LU/151/21/PL

25 River Road Littlehampton BN17 5BZ

Demolition of existing car garage and the erection of 2 no. two-storey residential buildings comprising 5 no. flats with associated works.

drawing Proposed lower ground floor

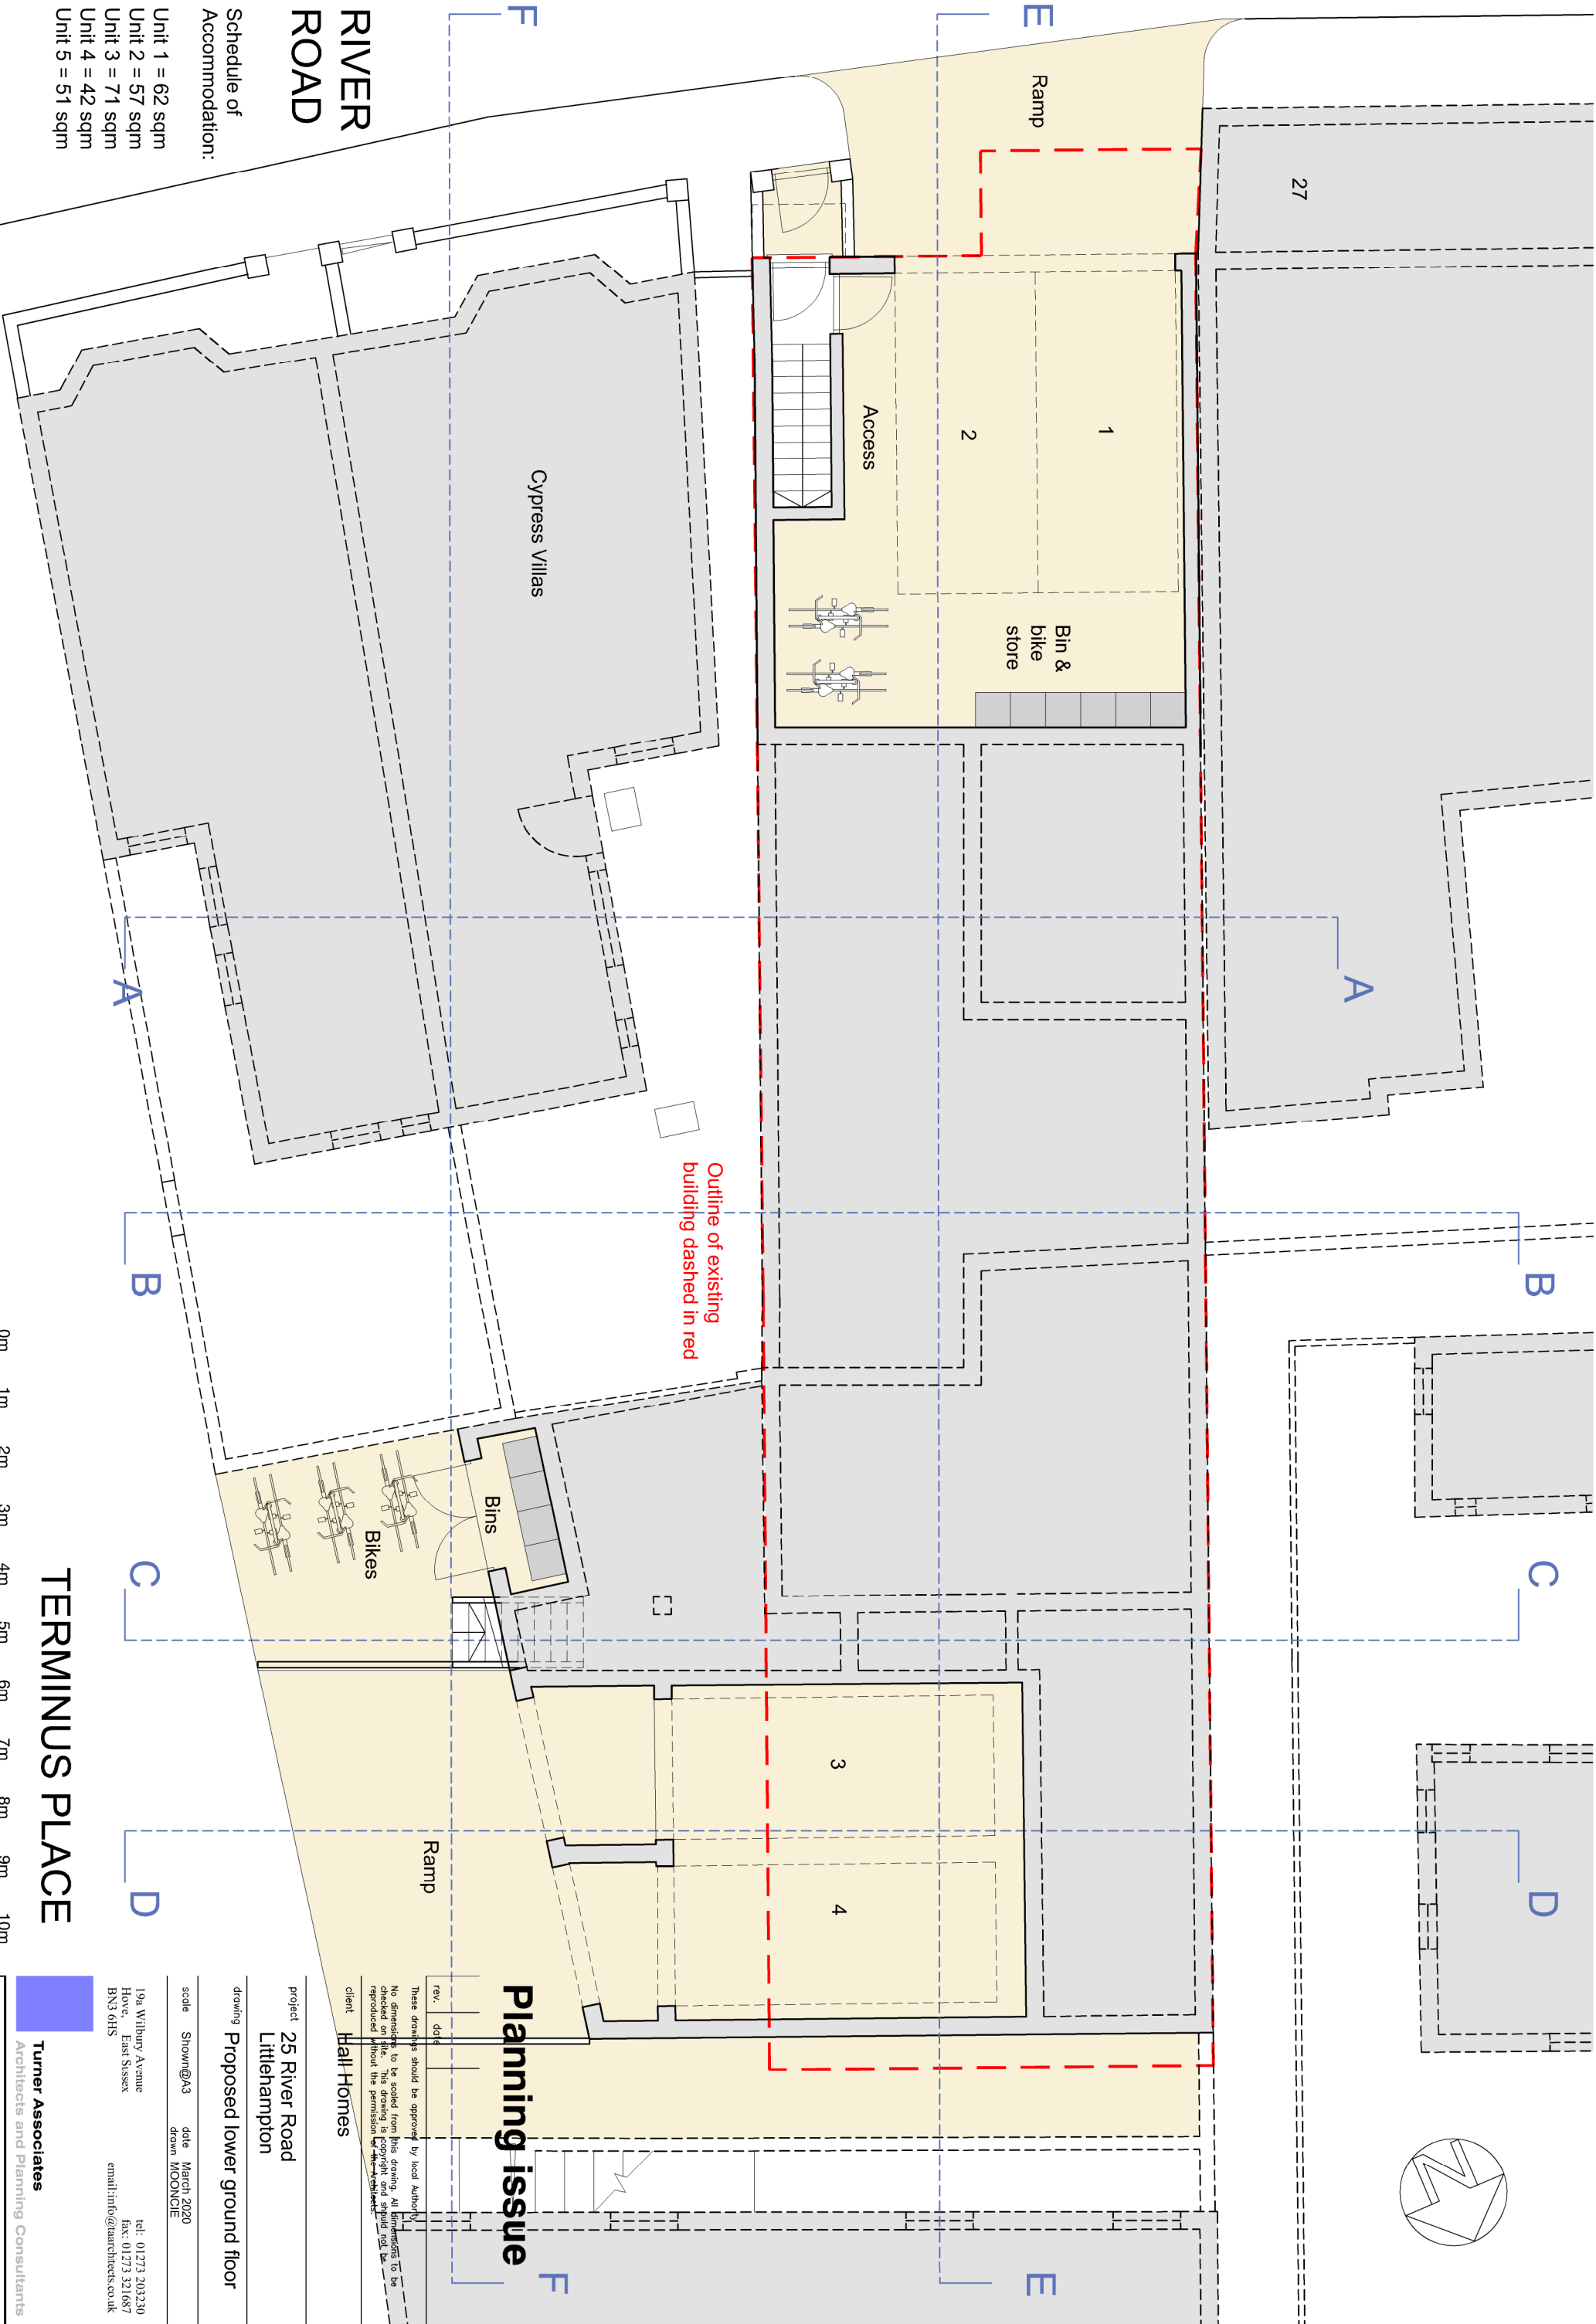
However, it is not clear how the proposed buildings are inspired by the various attractive, traditional properties within the conservation area. Whilst the idea of the semi-basement style car parking is understood in that it allows for the creation of off-street parking, it creates a raised ground floor, whilst also increasing the height of the buildings overall. It also results in the car parking area dominating what would normally be the ground floor area of any property. The fenestration pattern is also different from those in the immediate area where bay windows are present and limited, if any, Juliet balconies are seen. Therefore, the front elevations of both buildings appear out of character with those of a more traditional construction in the conservation area.

Whilst the proposed block of apartments in Terminus Place are now similar in height to the existing traditional properties, they have a more complex front elevation, which is out of character, this is enhanced by the undercroft car parking and the raised terrace area at the upper ground floor level.
